Application Ref:	3/2026/0106			 Ribble Valley Borough Council www.ribblevalley.gov.uk	
Date Inspected:	N/A	Site Notice:	N/A		
Officer:	LW				
DELEGATED ITEM FILE REPORT:				Decision	PERMISSION NOT REQUIRED

Development Description:	Prior notification for general purpose agricultural storage building 18.28m long, 15.24m wide, 8.83m high to eaves, 9.88m high to ridge.
Site Address/Location:	Plane Tree Farm, Chipping Road, Chaigley, BB7 3LT.

DRAWING TITLE:
SITE LOCATION PLAN

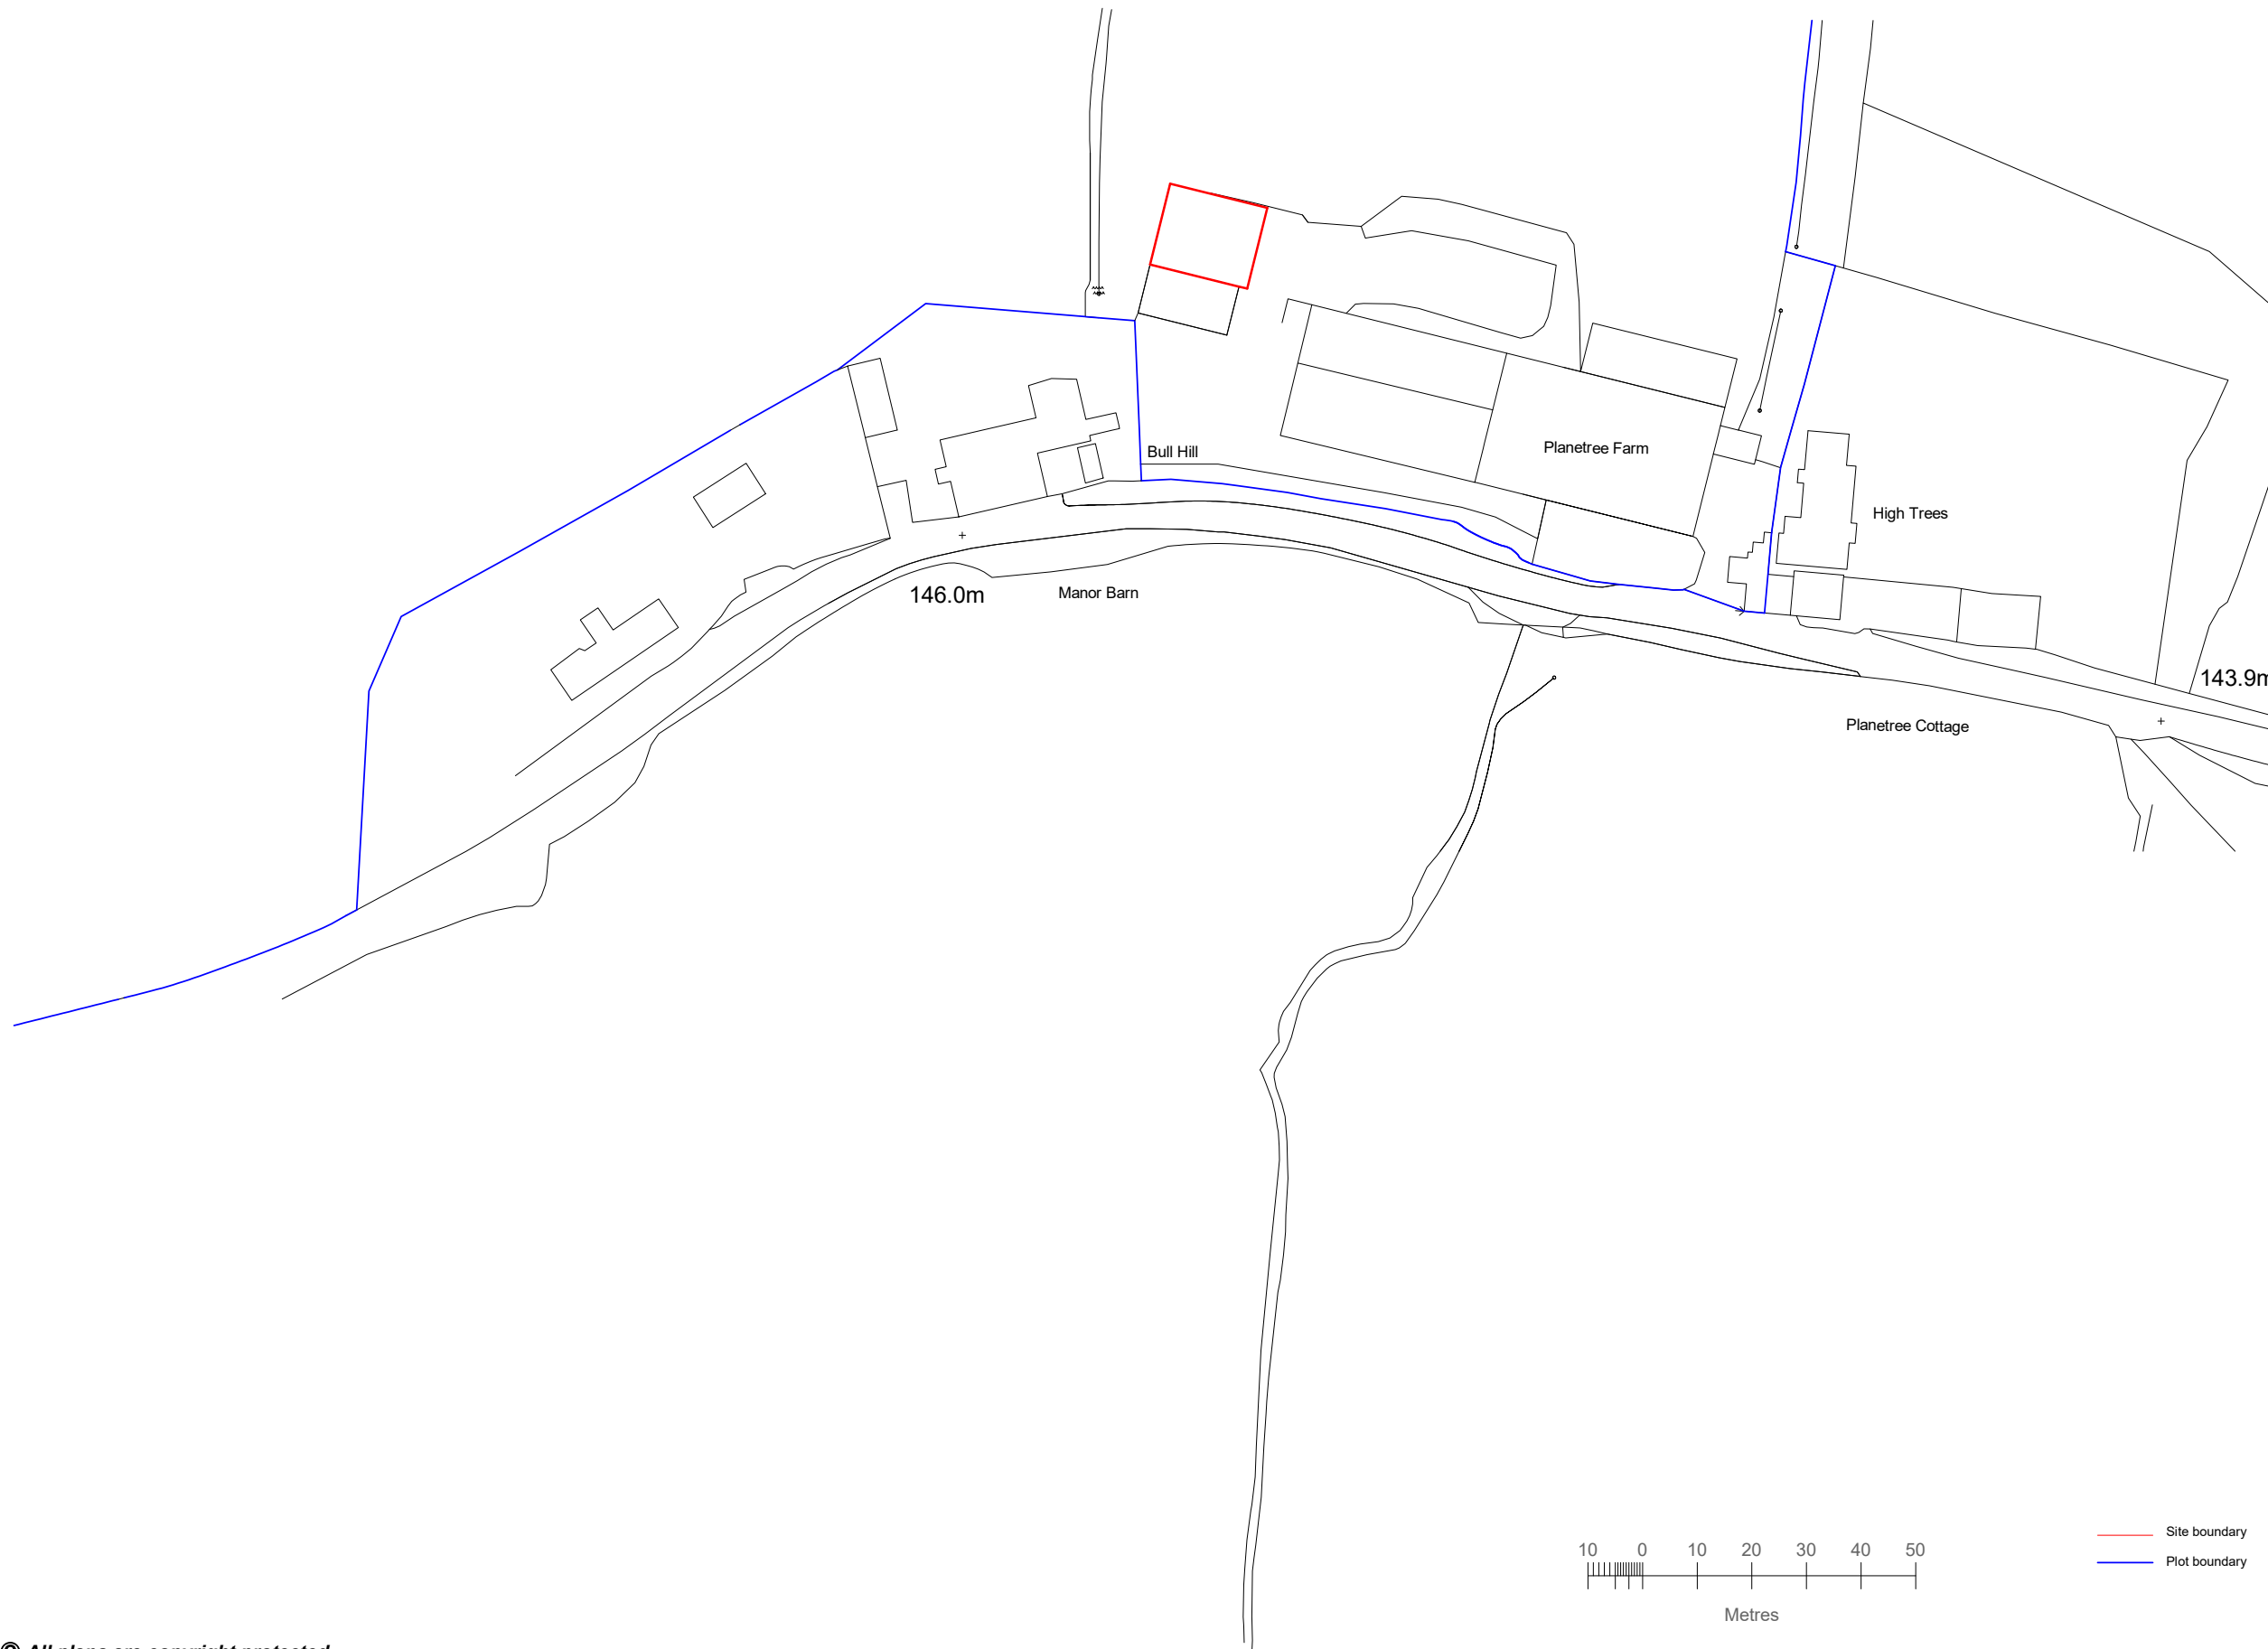
However, the proposal would be sited within the consultation zone of a SABIC Ethylene Pipeline and within close proximity to a United Utilities trunk main. As such, prior approval is required in terms of siting given it is unknown whether the proposal would affect these infrastructure assets.

A consultation response from United Utilities has also been received. Concerns have been raised with respect to the close proximity of the development to the large diameter trunk main and its associated legal easement and the possibility that as the scheme progresses, it may be discovered that the plans are not implementable in their existing form, resulting in the application having to re-submit a new application. United Utilities have also requested the imposition of a condition on any approval requiring details of the means of ensuring the water main is protected from damage are submitted to and approved in writing by the Local Planning Authority prior to work commencing.

However, whether or not the development proposed is implementable is not a matter for consideration as part of this prior approval application. Furthermore, it is the applicant's responsibility to adhere to the provisions stated within the easement document dated 03/10/1960 UU Ref: F2629, as well as the 'Standard Conditions for Works adjacent to Pipelines' during the development. With this in mind, the siting of the development is considered acceptable.

As such Prior approval is required and approved in terms of siting.

DRAWING TITLE:
PROPOSED ELEVATIONS

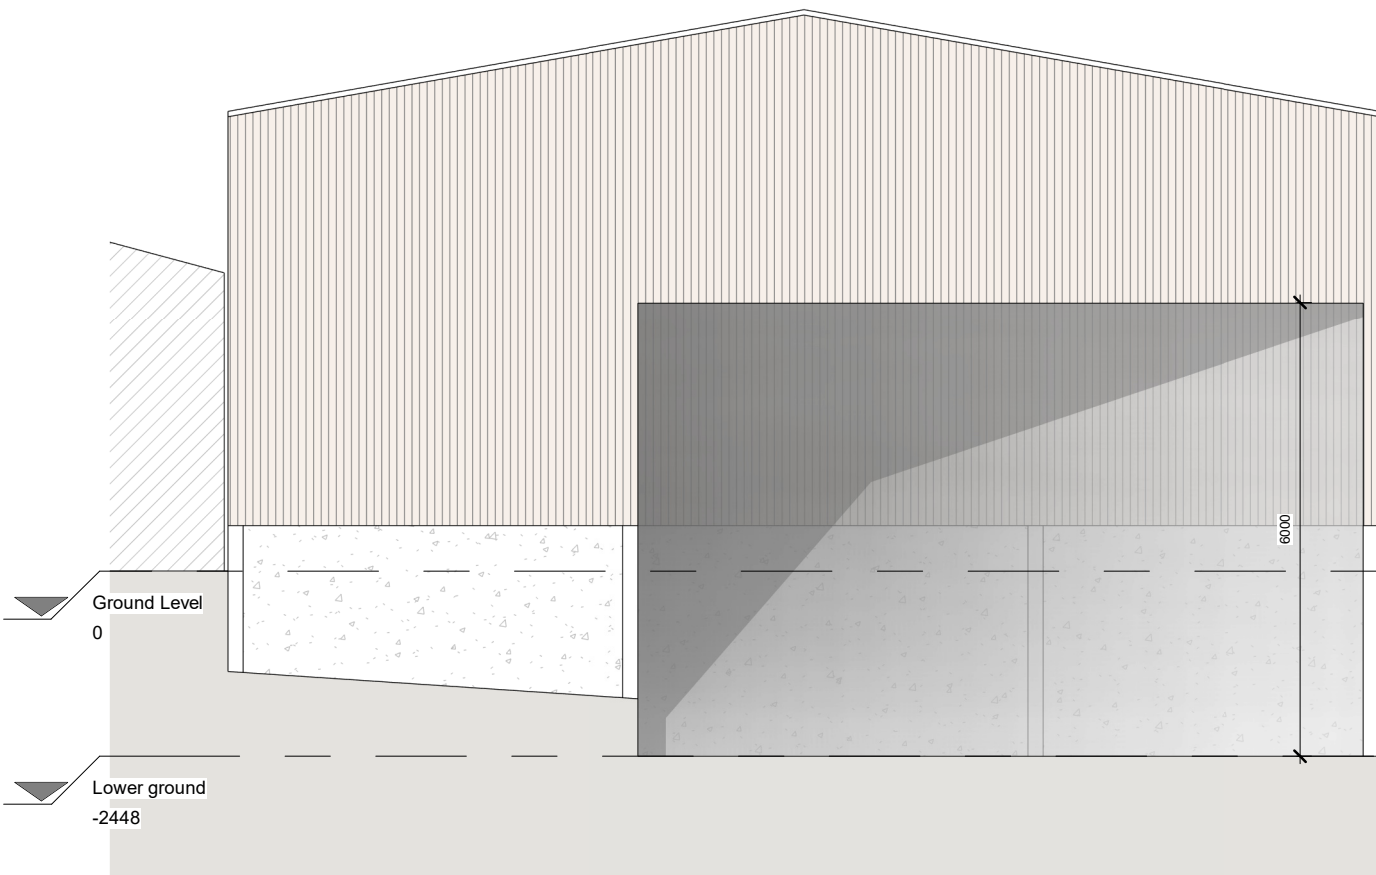
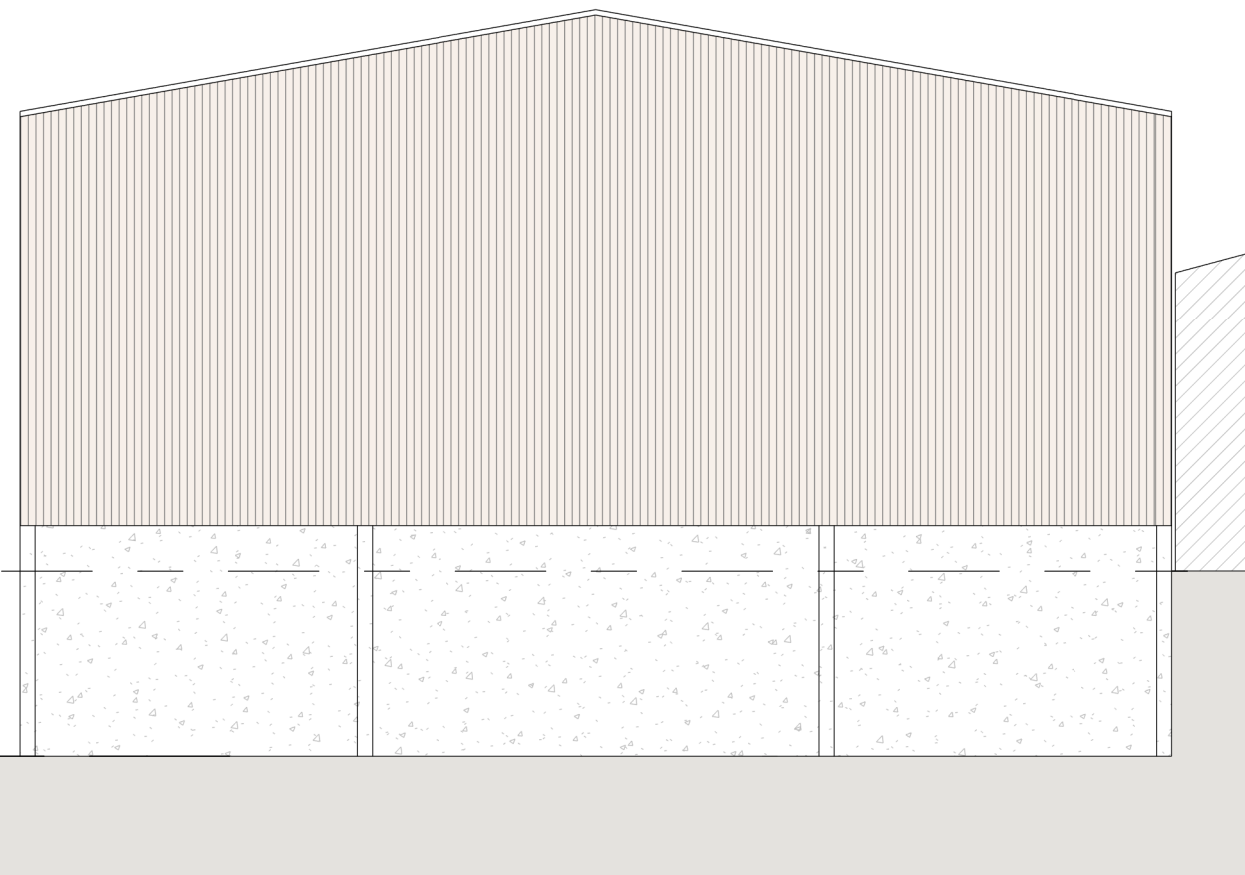
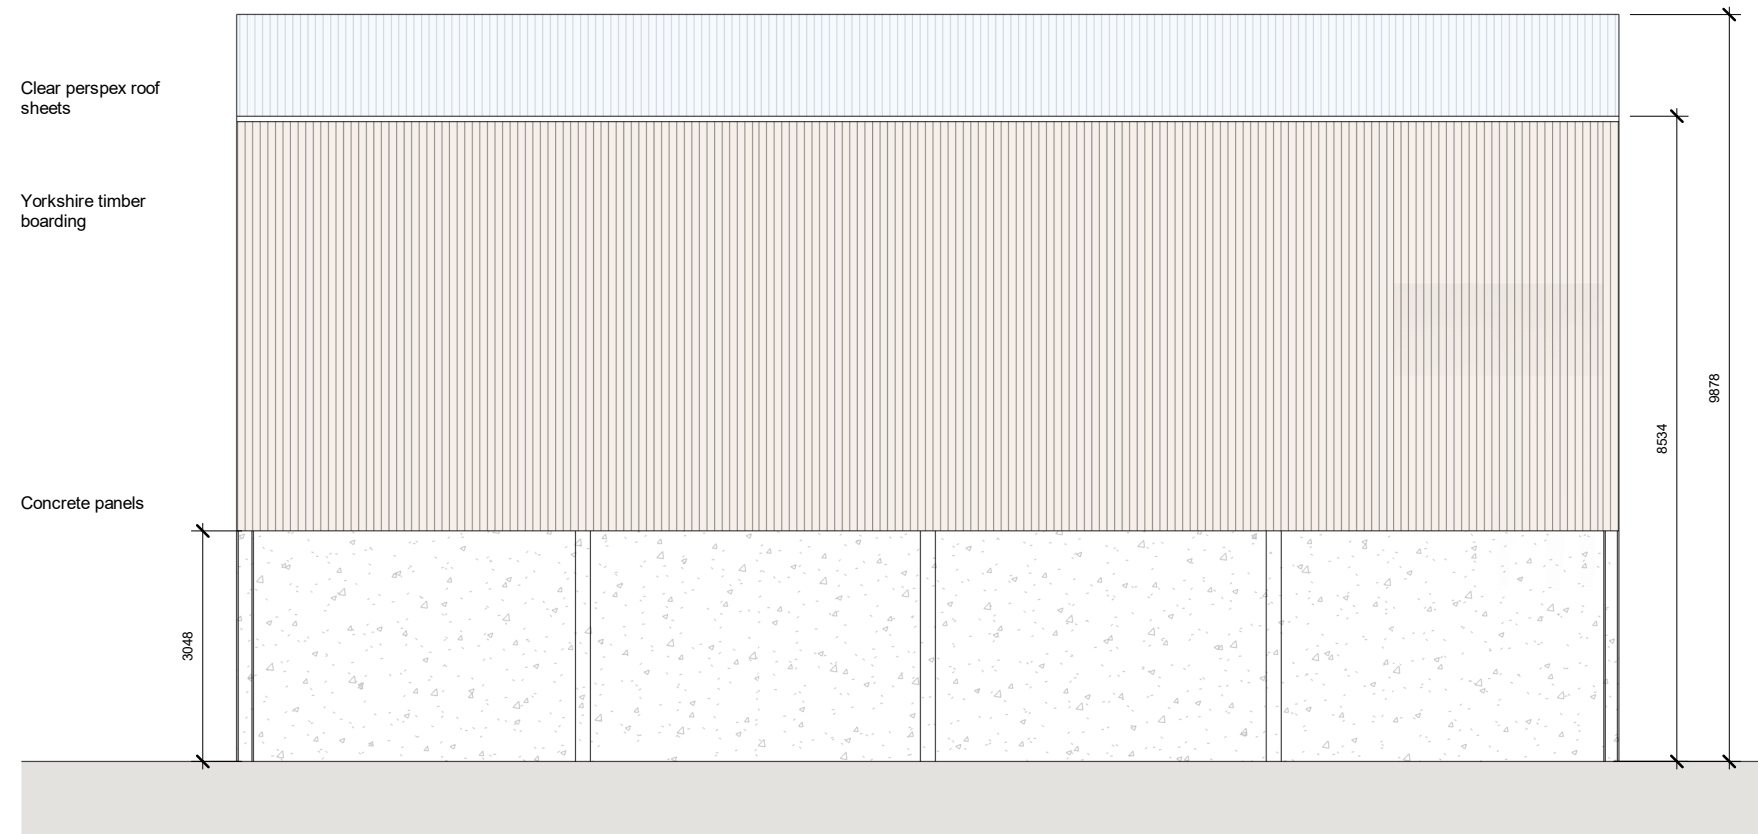
The building would comprise a considerable height. However, it is understood following discussions with the Agent that the building is to be utilised for the storage of concentrates for the milk cows, as well as the storage of straw and other items, and that the most financially friendly way of purchasing concentrates is to buy an arctic wagon load at once. As such, the height of the building is required in order to allow the wagons to fully tip their load inside the building, as this cannot be done in any current building on site.

In addition to the above justification, it is noted that the proposal would be set back from the public highway and viewed in context with the existing agricultural buildings at Plane Tree Farm. The development would also be sited on lower ground than the adjacent building directly to the south of the proposal which would help mitigate some of the resultant visual impact. With this in mind, the design/ appearance of the development is, on balance, considered to be justified and acceptable.

As such Prior approval is not required in terms of design and appearance.
